Mr Peter McManus  
Department of Planning and Environment  
GPO BOX 39  
SYDNEY 2001

**SSD 7054 and SSD 7055 – LEES 1 AND ADMINISTRATION BUILDINGS PROJECT – EIS**

#### LEES 1 (EXTENSION TO CARSLAW BUILDING) AND ADMINISTRATION BUILDING F23

Figure 2: Noise survey locations

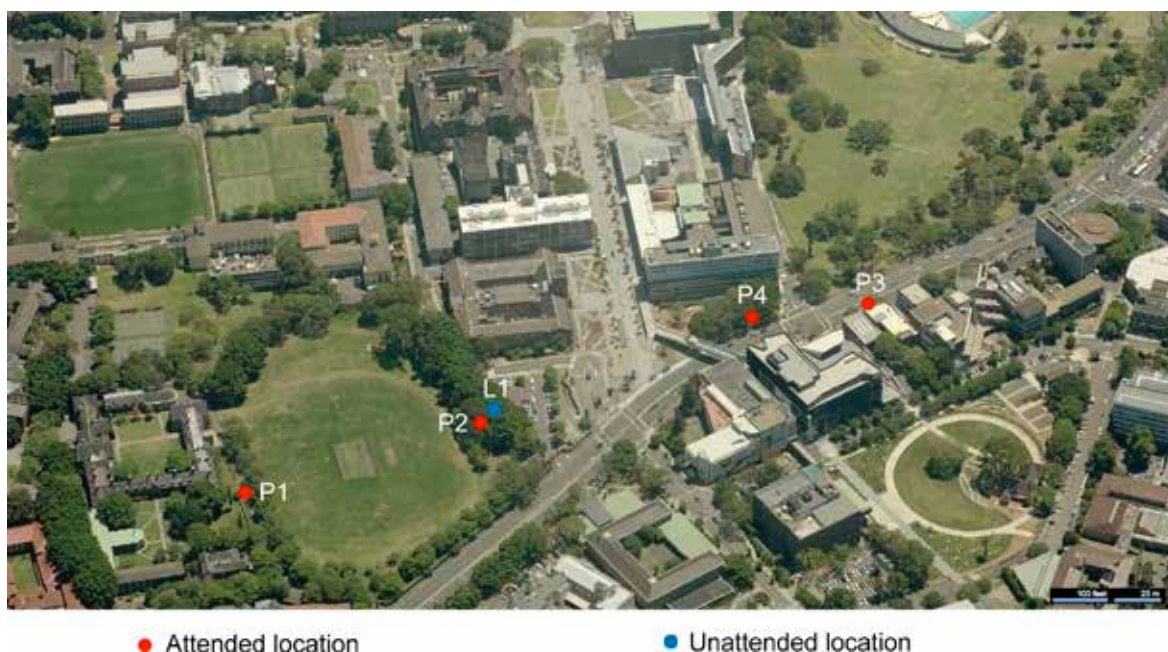
- (1) EIS Appendix T (LEES 1) -
  - (a) attended monitoring was likely to have been undertaken at street level, whereas the most affected residences are located above street level; and
  - (c) section 4.2 indicates that the weather was typically calm (BoM observations at it Observatory Hill automatic weather station indicate adverse meteorological conditions in that wind speeds exceeding 5 metres per second were observed on 28 and 29 July 2015, and on 1 to 4 August inclusive); and
- (2) EIS Appendix U (Administration Building) –
  - (a) Section 2.3 identifies 2 receiver locations
  - (a) Figure 1 indicates that background noise monitoring was only undertaken at receiver location 1 (i.e. proposed accommodation) and not at receiver location 2 which the most affected existing off-campus residence (i.e. boundary of St Paul's residential college at City Road)

- (a) provide a worst-case quantitative assessment of the 'night-time' background noise level in accordance with the guidance material provided in the New South Wales Industrial Noise Policy; and
- (b) ensure plant and equipment does not generate noise that exhibits tonal or other annoying characteristics.

Figure 3: Level 2 plant room location (highlighted in red)

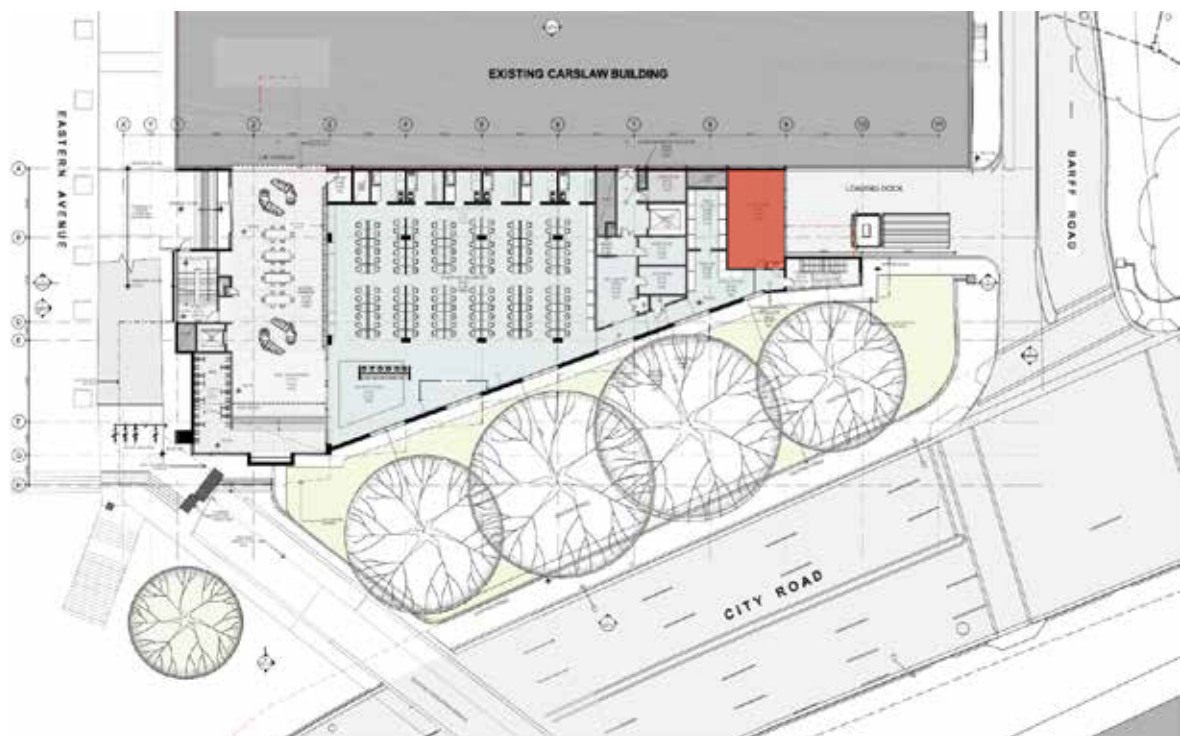
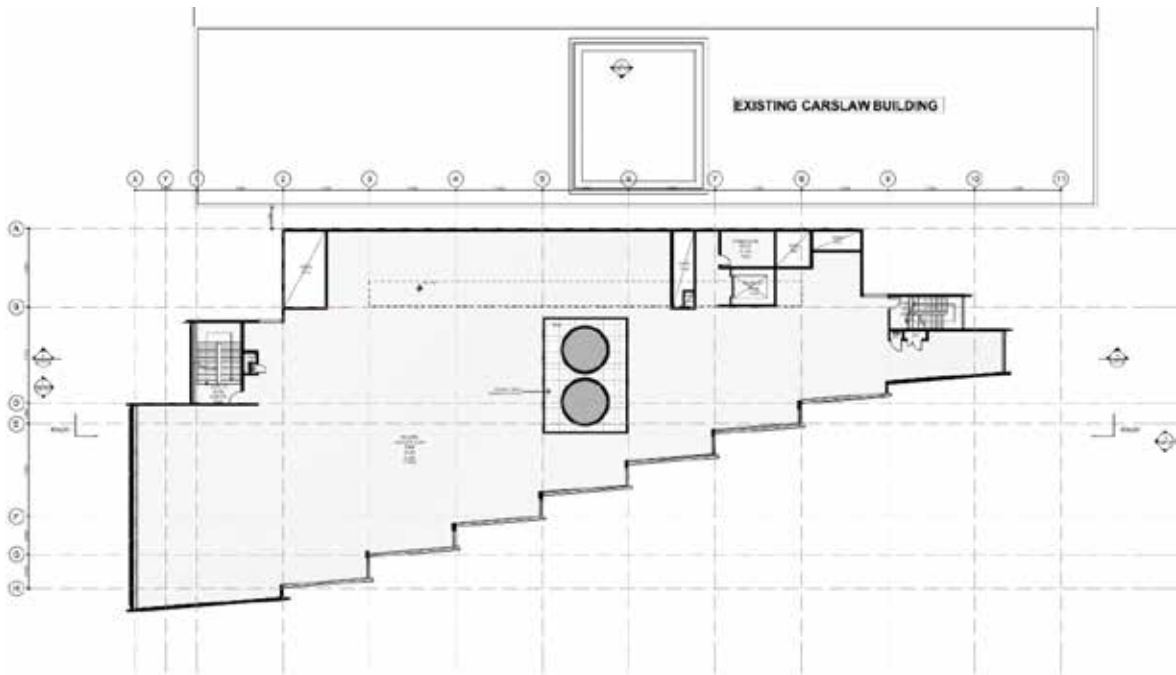
Section 6.2 to EIS Appendix T (LEES 1) indicates that certain mechanical ventilation plant will be required to operate at all times. However, section 6.3 to Appendix T does not provide a detailed prediction of noise impacts at the most affected off-campus residence but instead suggests a compliance criteria measured at each plant room boundary.
